ROLLIN RIDGE Filing No. 1 Grading & Erosion Control Plans El Paso County, Colorado

Remove Filing 1 and replace with
Pre-Development Grading & Erosion Control
Plans.

PCD FILE NO. SF-19-022

EGP-20-006
(typ all sheets)

SHEET: **G2**

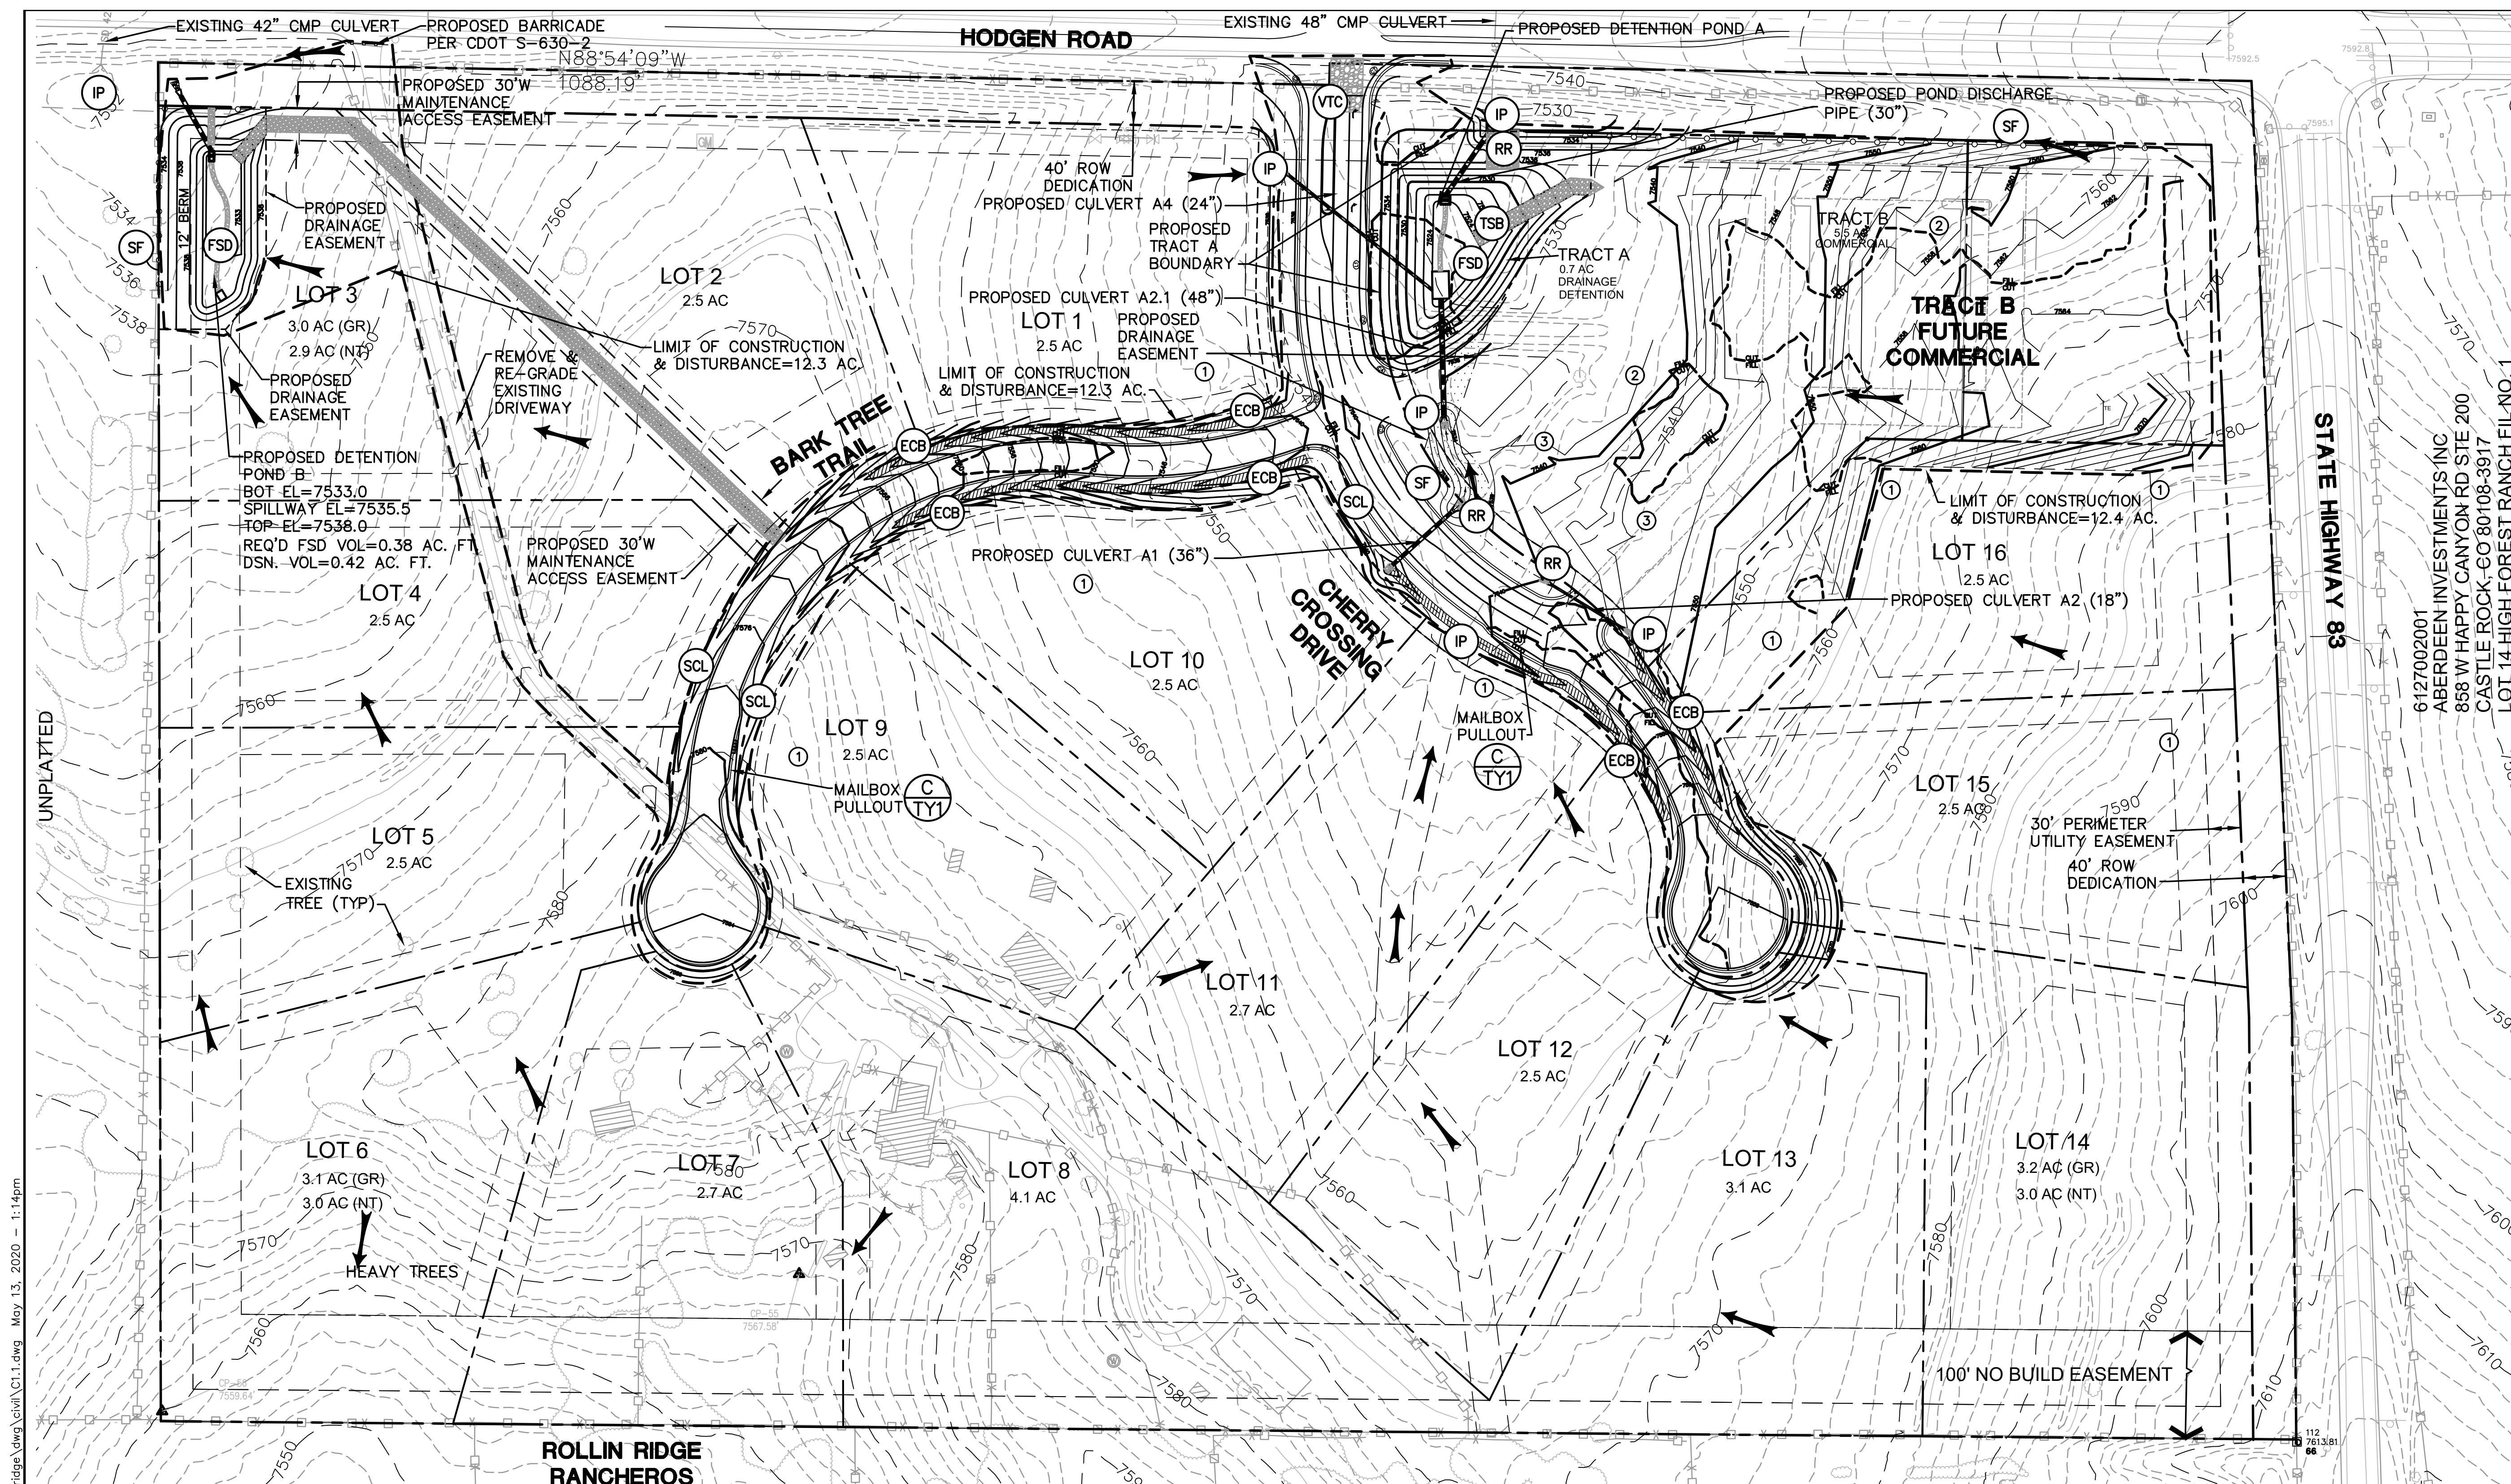
Item I - Discuss existing vegetation

C1.1

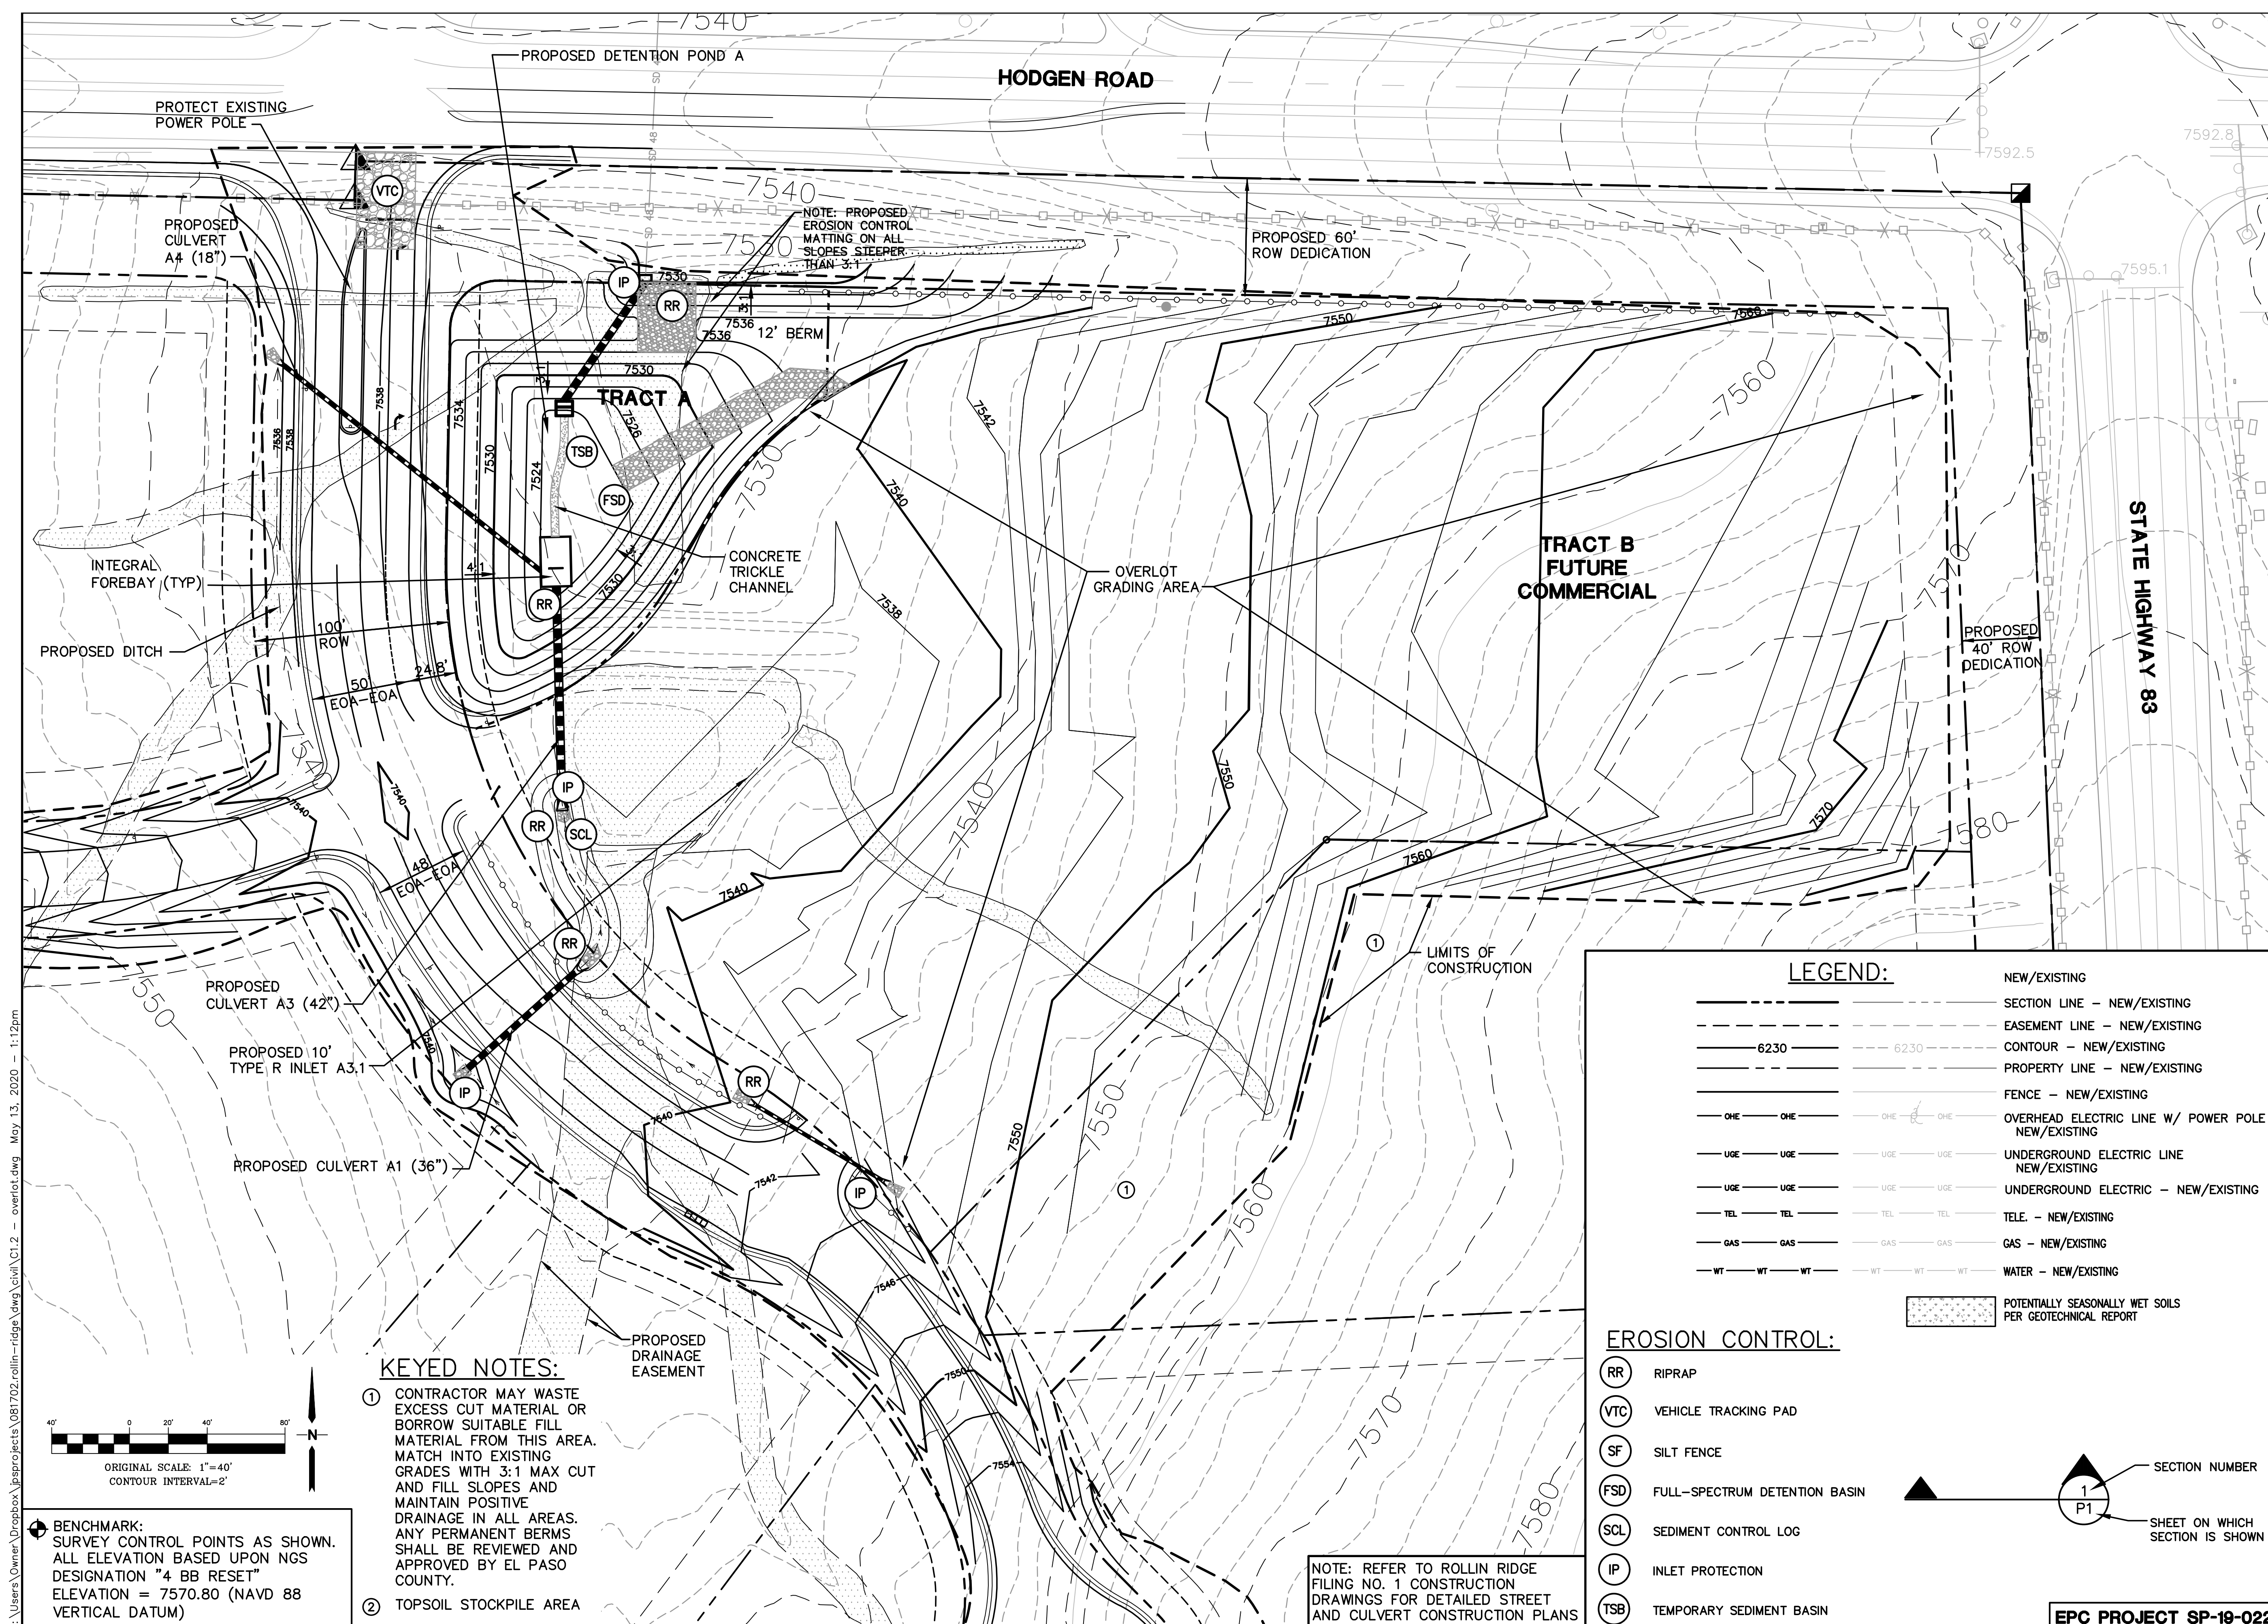
Show approx limits of these areas with appropriate control measures (like perimeter silt fence).

Include the following items in Legend:
 - cut/fill line
 - Limits of Disturbance / Construction
 - Drainage arrows
 - Concrete washout area

Remove permanent pond structures. Early grading application is for earthwork activities only and temporary bmp.
